Approval of reserved matters following outline consent WA/26/18/OUT for layout & scale for 6 No. dwellings & 6 No. detached garages.

Lanes End West Walberton Lane Walberton

Thank you for your internet representation made on 3rd December 2019 which has been recorded as '**an objection**' with the comments as follows:

PJ DEVELOPMENTS LTD 2 Square Chambers 23 High Street Emsworth PO10 7AQ Tel: 0843 289 3430 Email: enquiries@pjdevelopmentsltd.com	
PROJECT: FORMER LANES END	
SITE PLAN OUTLINE PLANNING APPLICATION	
DATE: JANUARY 2019	DWG. NO 19-001 PL02
SCALE @ A1: 1:200	
REV: C

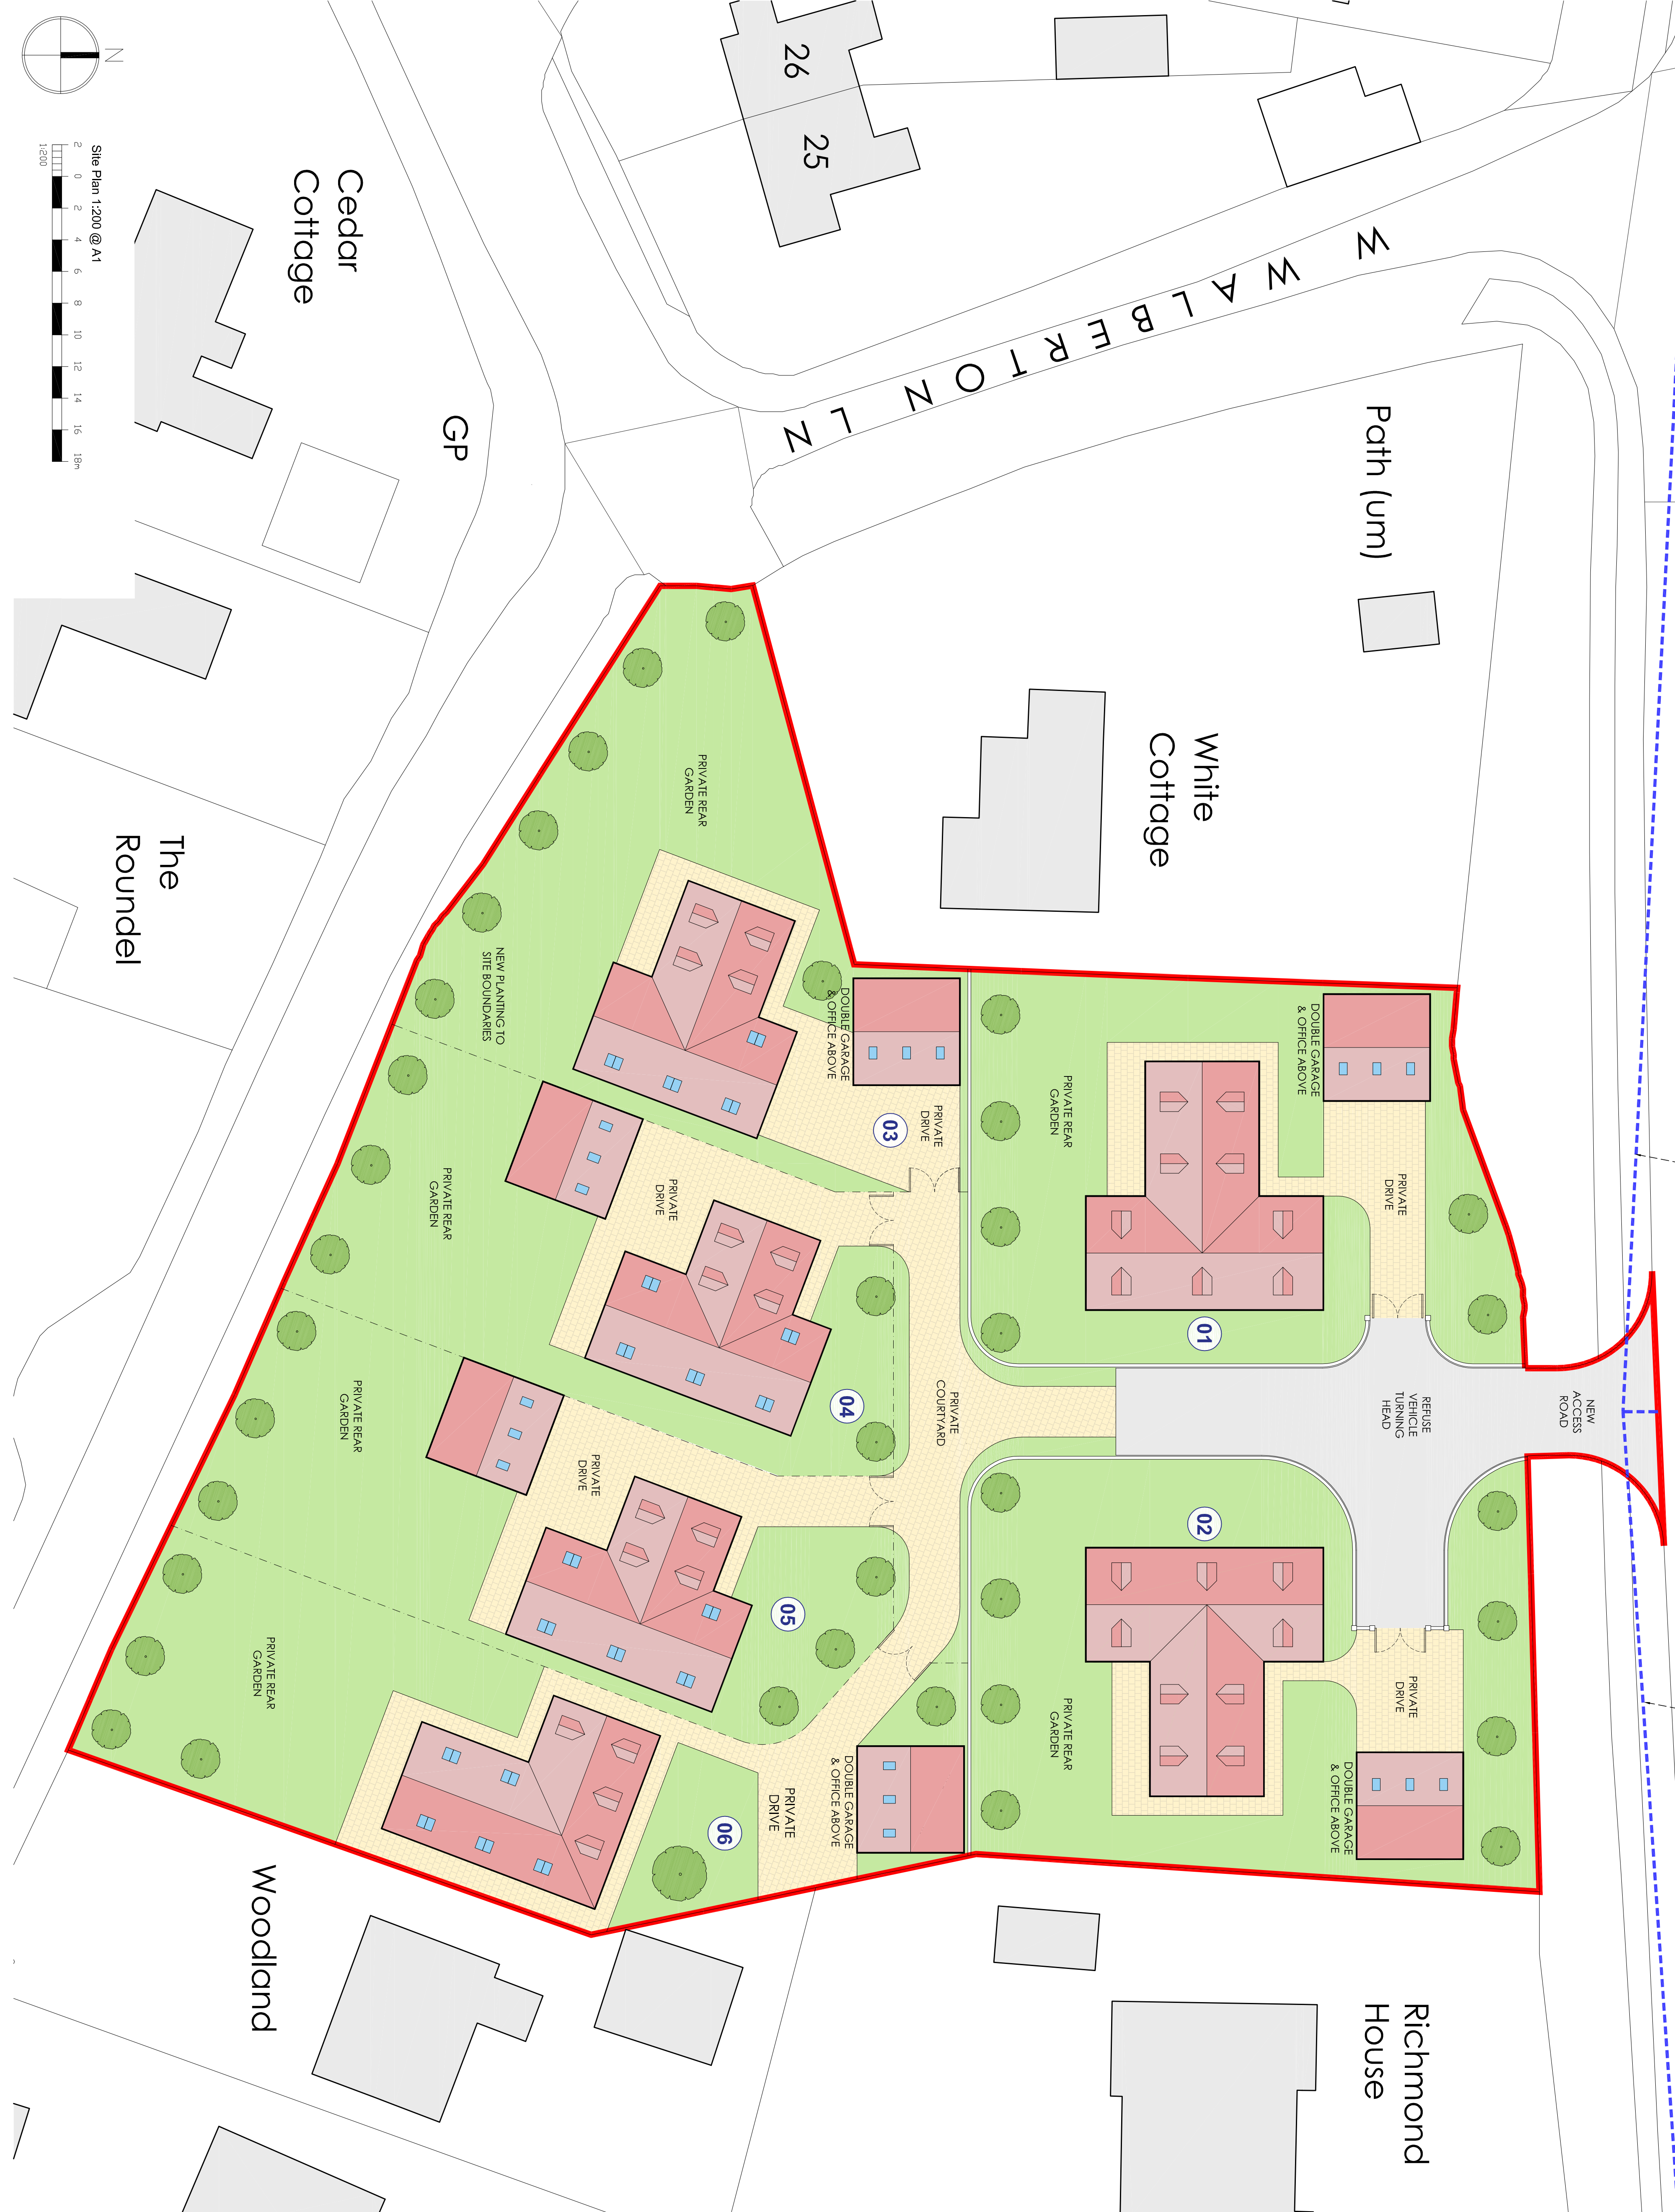
*I am unhappy with Option Unit 6. I request that Unit 6 be moved further north so that it does not obscure the sunlight and I do not lose my privacy.
It would also save cutting down more trees*
